GG119 ROAD SAFETY AUDIT RESPONSE REPORT

Project Title:	Roslyn Avenue, Netherton, Huddersfield
Project Team:	Harron Homes / Elston Engineering Ltd
RSA Report Stage	Stage 1
RSA Organisation:	Sanderson Associates Consulting Engineers
RSA Report Reference:	Stage 1 Road Safety Audit
RSA Report Issue Date:	March 2026
Report Title:	Stage 1 Road Safety Audit
Reference:	400187-001

This Road Safety Audit Response Report relates to a Stage 1 Road Safety Audit carried out by Sanderson Associates Consulting Engineers for the proposed residential development on land off Roslyn Avenue, Netherton. The development comprises the construction of 82no. residential properties with associated adopted highways.

drawing title:
Highways Area Plan

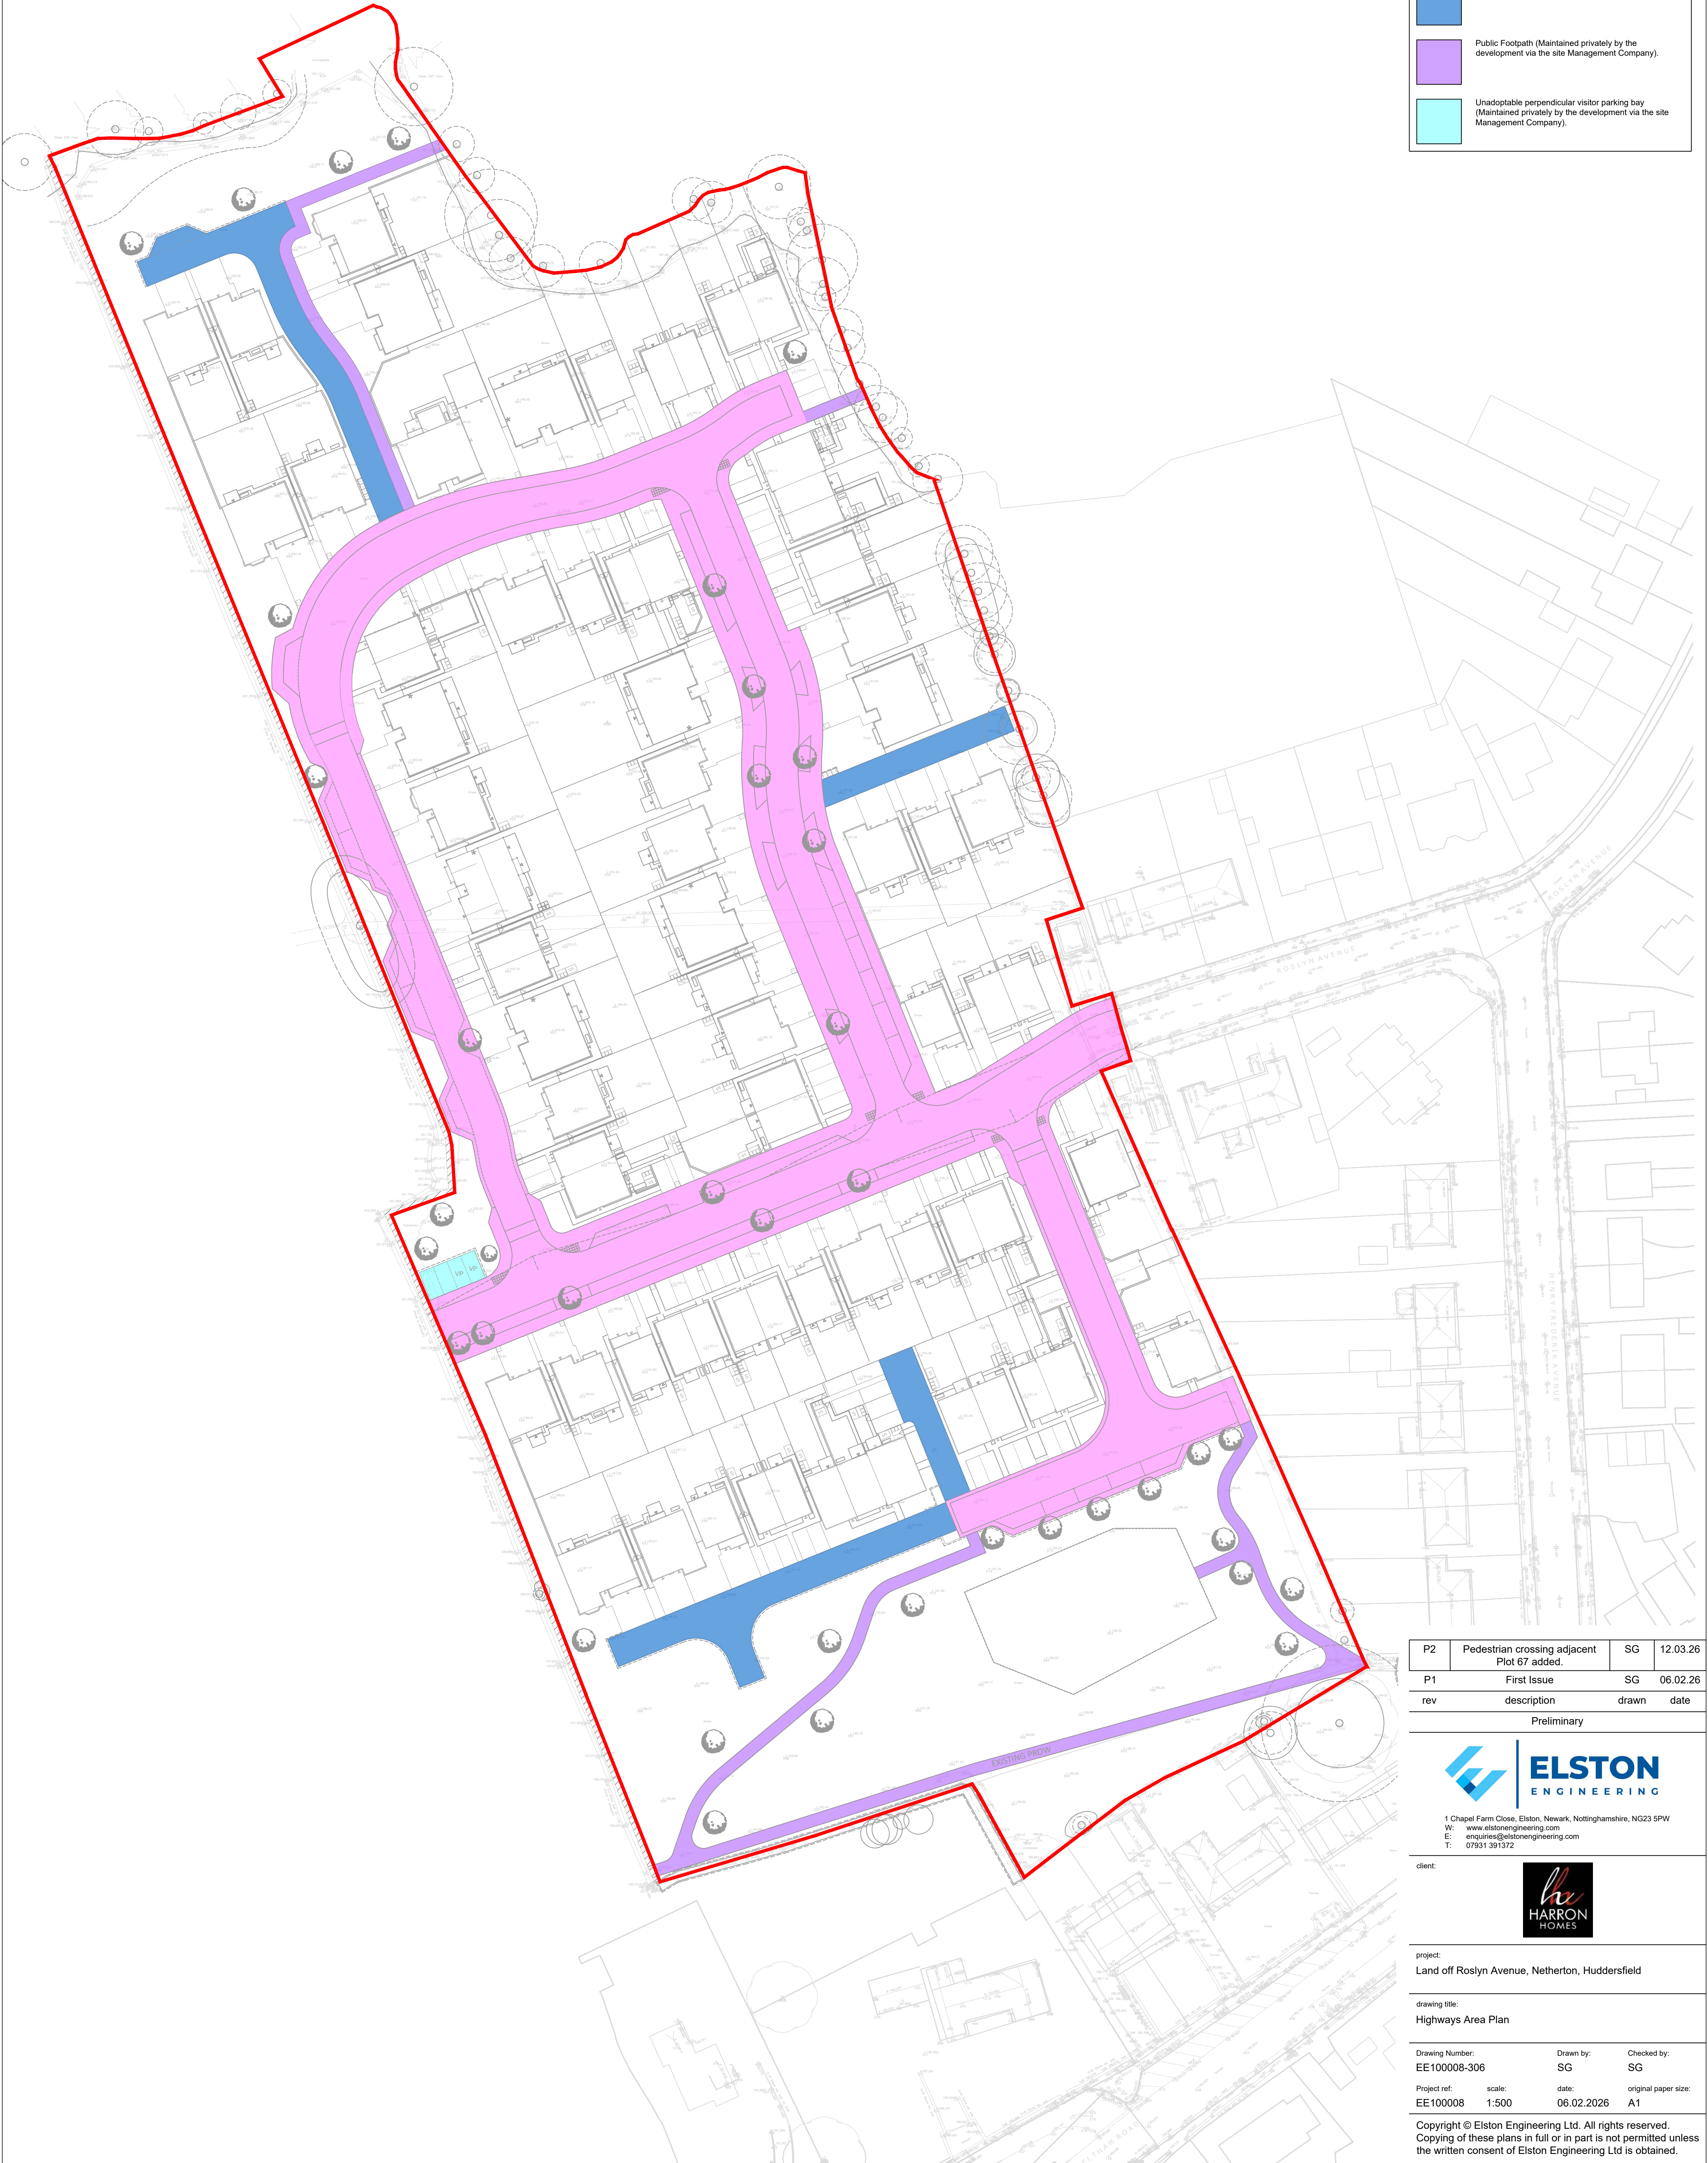
Proposed dropped kerb pedestrian crossing facilities are indicated on the Section 38 Layout Plan at the majority of significant junctions within the development. However, no dropped crossing provision is shown at the junction located at the north-east end of the loop road. There is a footpath link to and from the development adjacent to Plot 67 that connects to this junction, which is likely to generate pedestrian movements across the carriageway at this location. The absence of a dropped crossing may therefore result in an inconsistent level of pedestrian provision and may create difficulties for mobility-impaired users, wheelchair users, and those with pushchairs attempting to cross the carriageway. This may discourage pedestrians from using the footway network as intended or lead to informal crossing at locations without appropriate tactile paving or level access.

It is recommended that a dropped kerb pedestrian crossing point be included in the design at this junction including appropriate tactile paving.

Tactile paved pedestrian crossing included at the junction adjacent Plot 67 to aid pedestrian movements.

Proposed Highways Plan

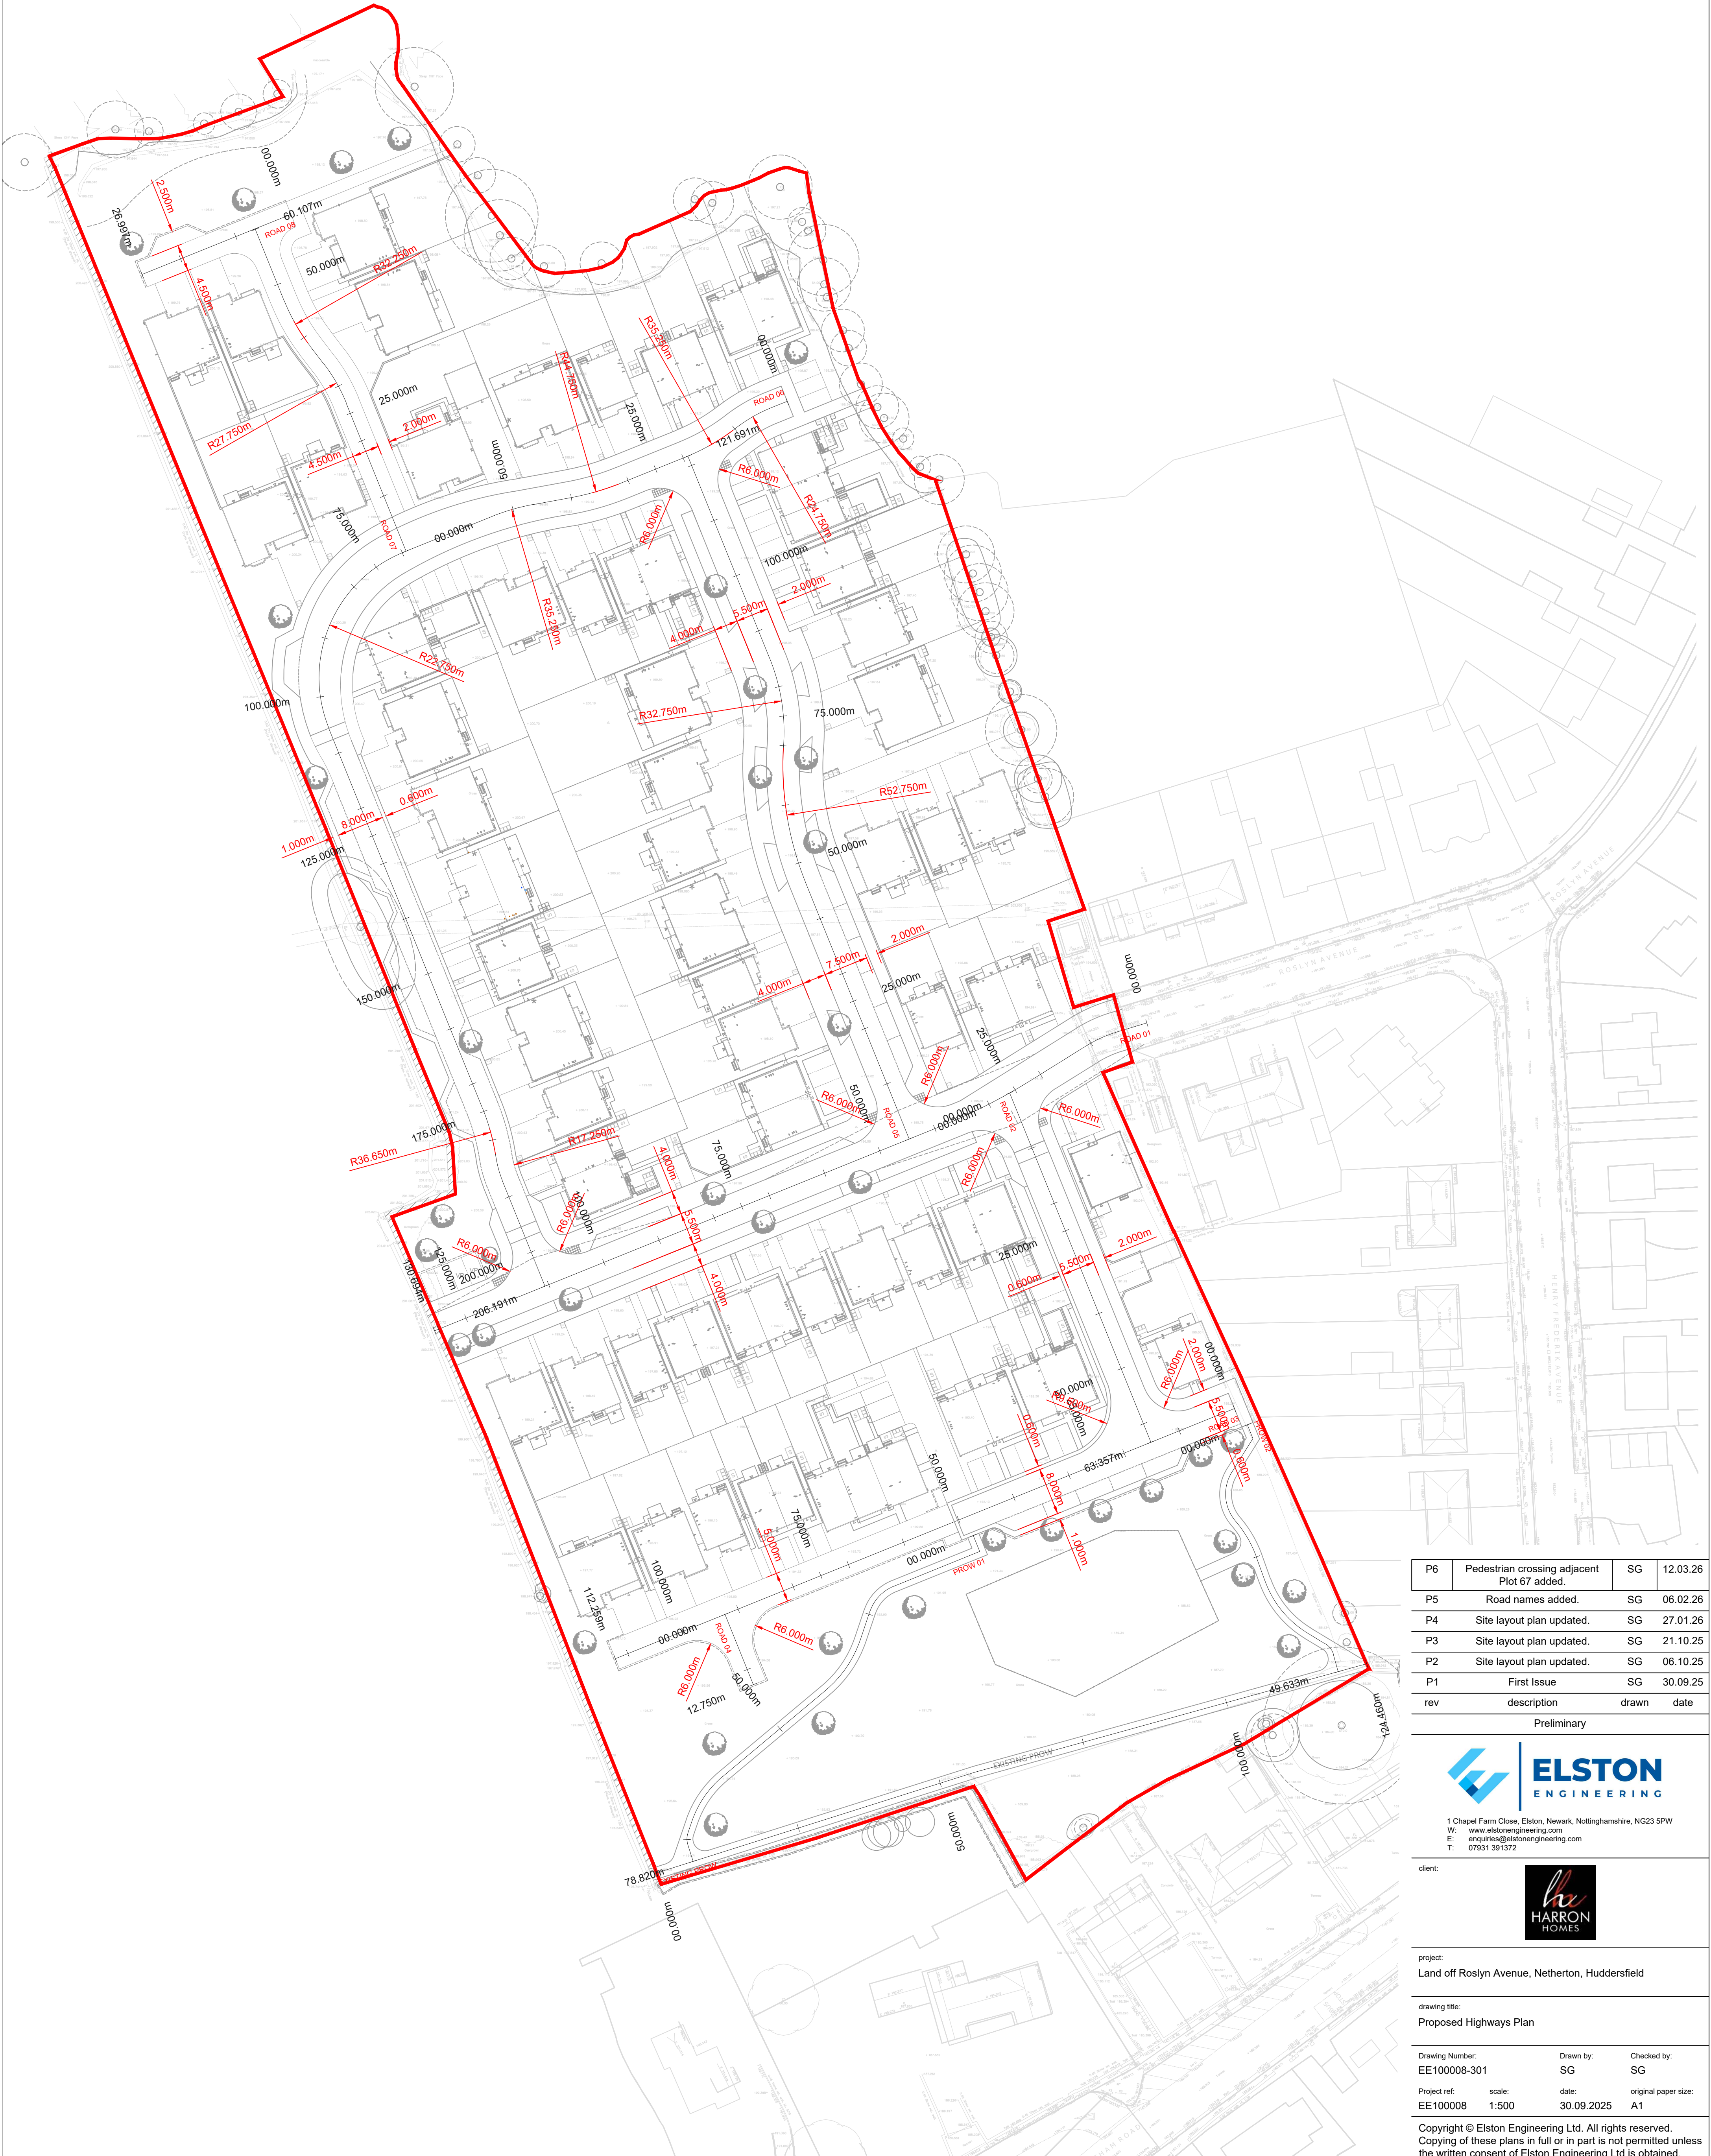
Dropped crossings with tactile paving are now shown on the drawings (including EE100008-301 P06) at the junction adjacent to Plot 67, and are acceptable in principle. However, the location of this new dropped crossing may be better inset further into the junction, similar to the arrangement shown at the junction further to the south. This change can be picked up at the detailed design stage as part of the S38 technical approval process, and reviewed further as part of the required Stage 2 RSA process.

All tactile paving and dropped crossing designs to be reviewed and agreed with S38 Team at the detailed design stage.
